PCD Project Manager_2026-06-10_004 - Site Development Plan.pdf Markup Summary

Subject: Text Box
Page Label: [57] S-1 Site Development Plan
Author: dsdparsons

ARCHITECTURAL SITE PLAN

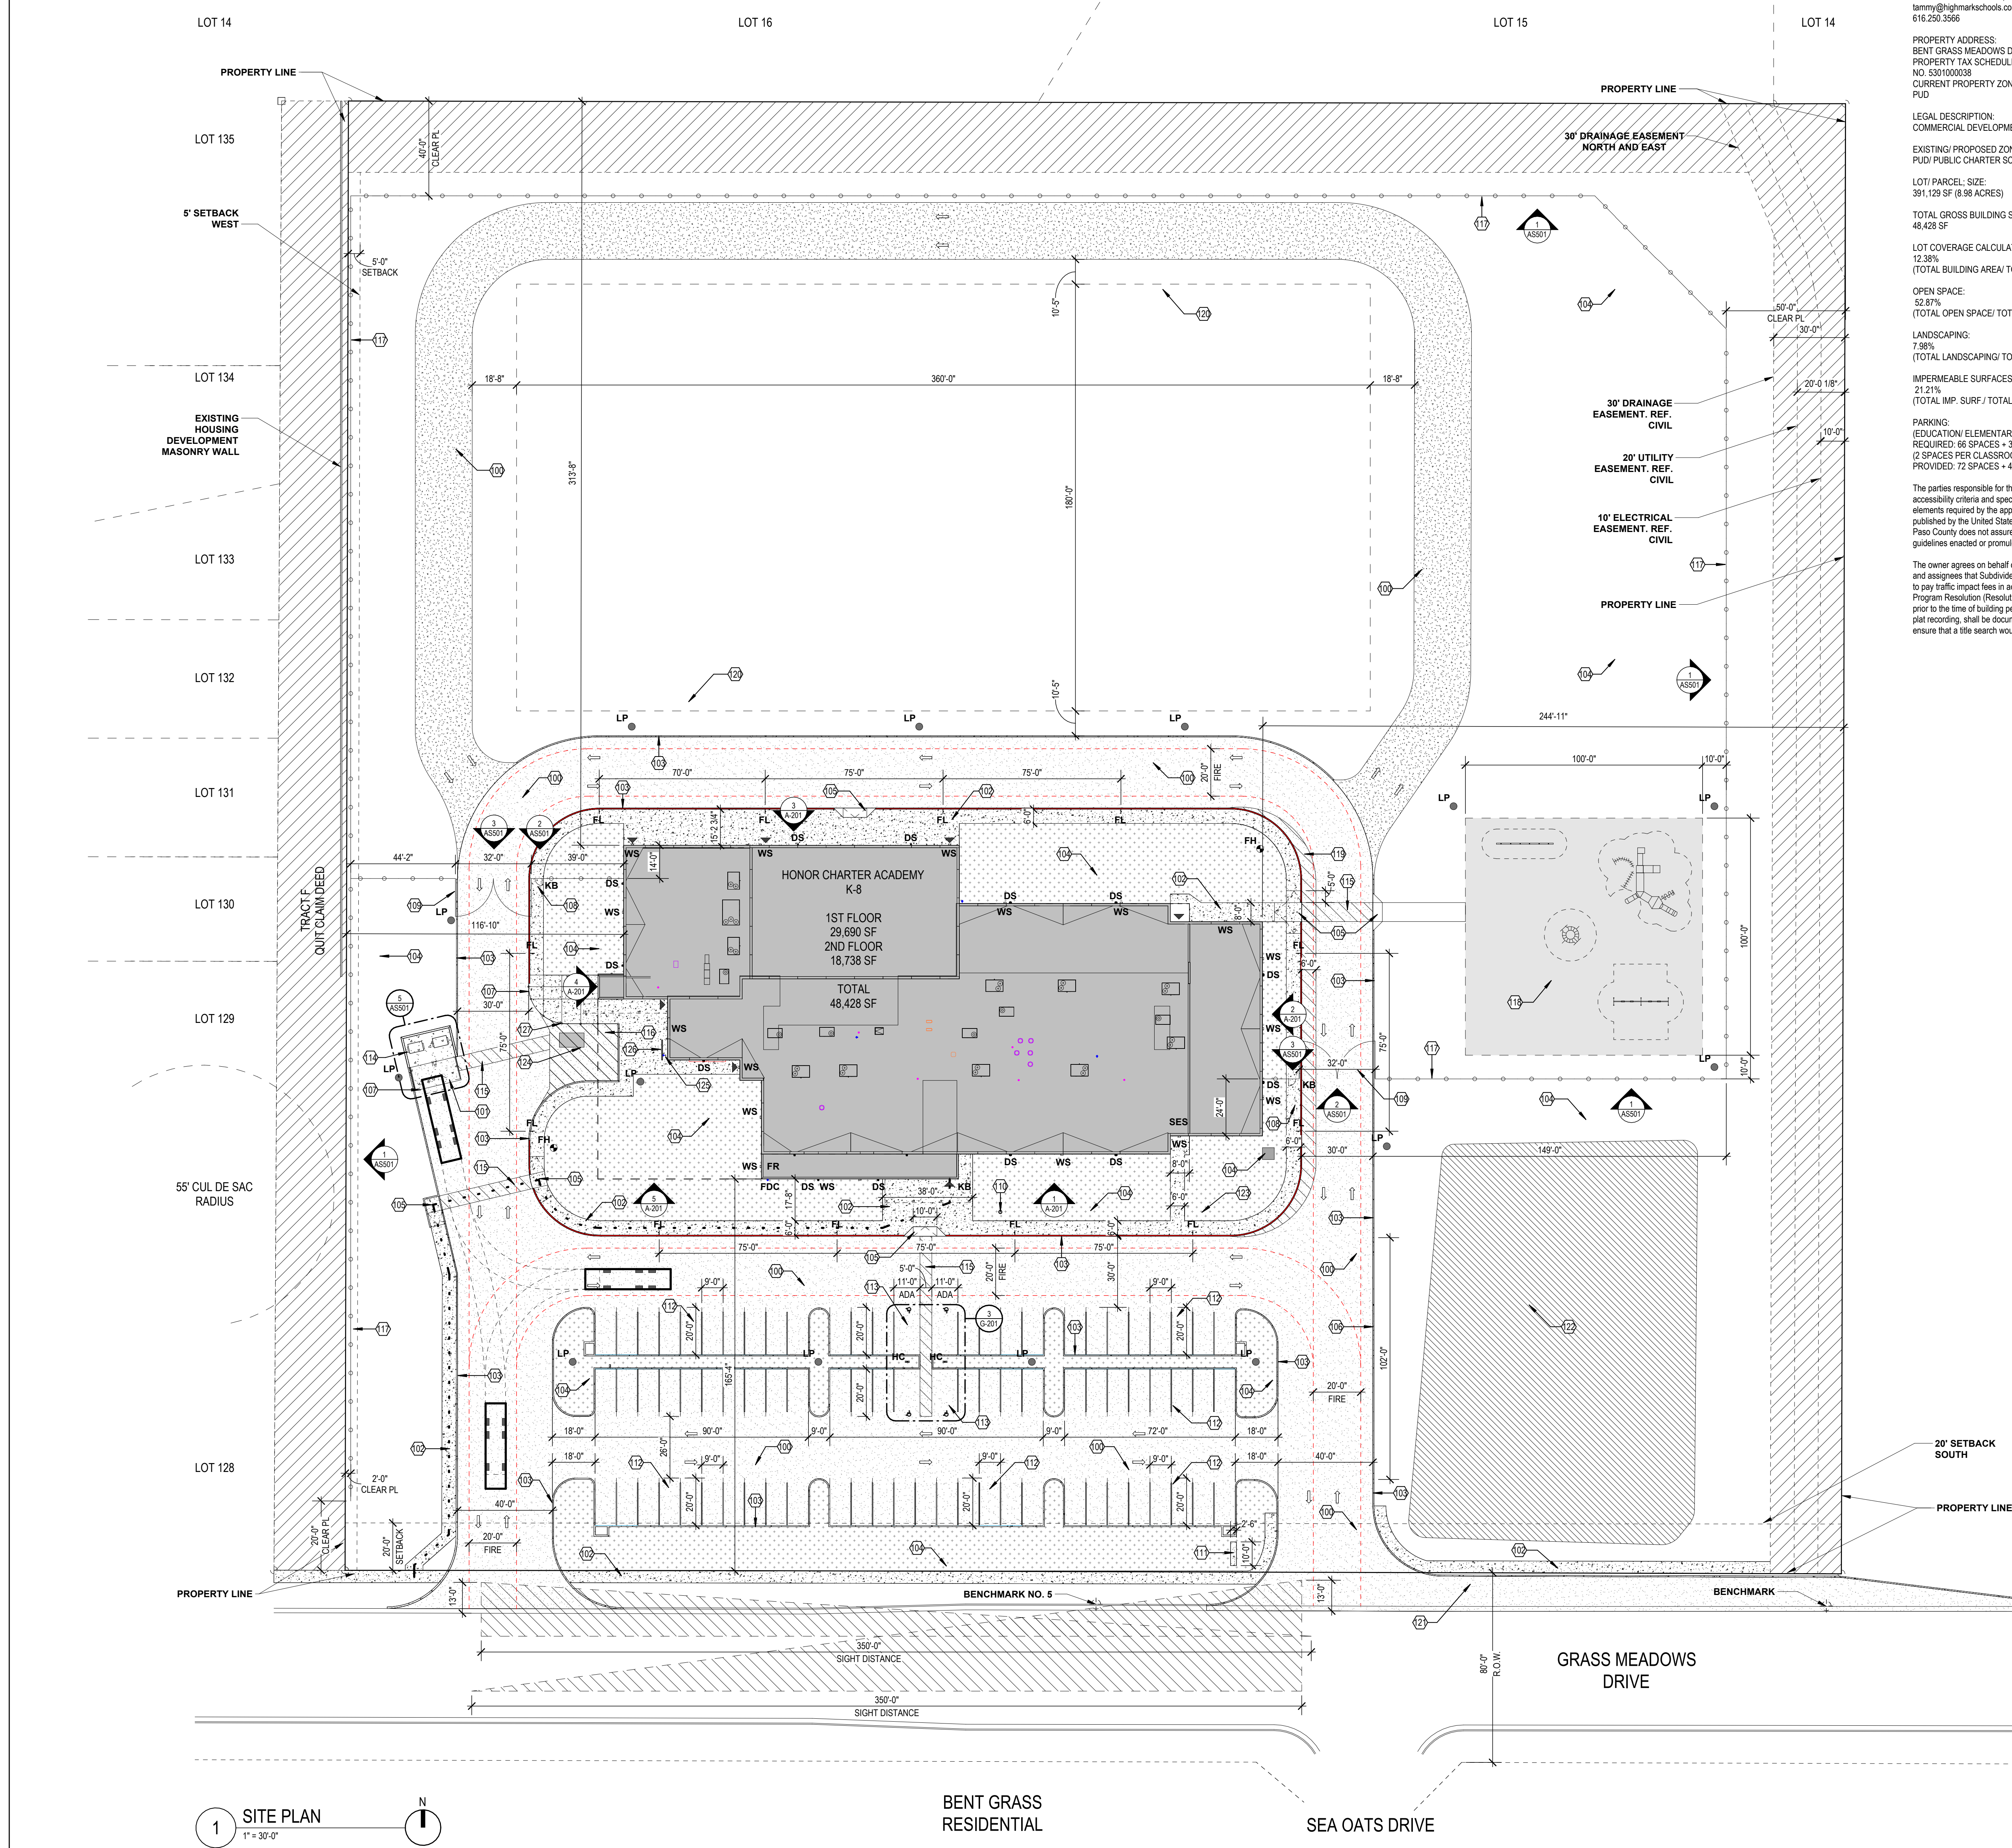
Show all property lines and depict 25 foot building setbacks per the checklist and provide landscape , buffer setbacks per Chapter 6

Please provide the parking plan and table on a sheet based on the Land Dev Code . Identify dimensions, ADA spaces, Loading/drop off areas, Bus Parking ; staff Parking (you will need both categories since you are 2 schools in one)

is an opaque buffer screen wall provided adjacent to residential homes? a 15' buffer is required.

what is this area? what is surface

depict the playground as it is to be approved with this site dev plan

is there a chained Emergency access?

RESPONSE: BUILDING AND LANDSCAPE SETBACKS HAVE BEEN ADDED. PUD DICTATES THE REQUIRED BUILDING SETBACKS. PER PUD, 20' FRONT AND REAR, 5' SIDES. CHAPTER 6 SPECIFIES 15' LANDSCAPE SETBACK.

RESPONSE: SCHOOL IS A K-8 ONLY.

RESPONSE: EXISTING 8' SOLID WOOD PICKET FENCE TO REMAIN.

RESPONSE: SODDED ATHLETIC FIELD

RESPONSE: PLAYGROUND DETAIL ADD

RESPONSE: THERE IS NOT A CHAINED EMERGENCY ACCESS IN THIS LOCATION. THERE CURRENTLY IS A BARBED WIRE FENCE IN THIS LOCATION.
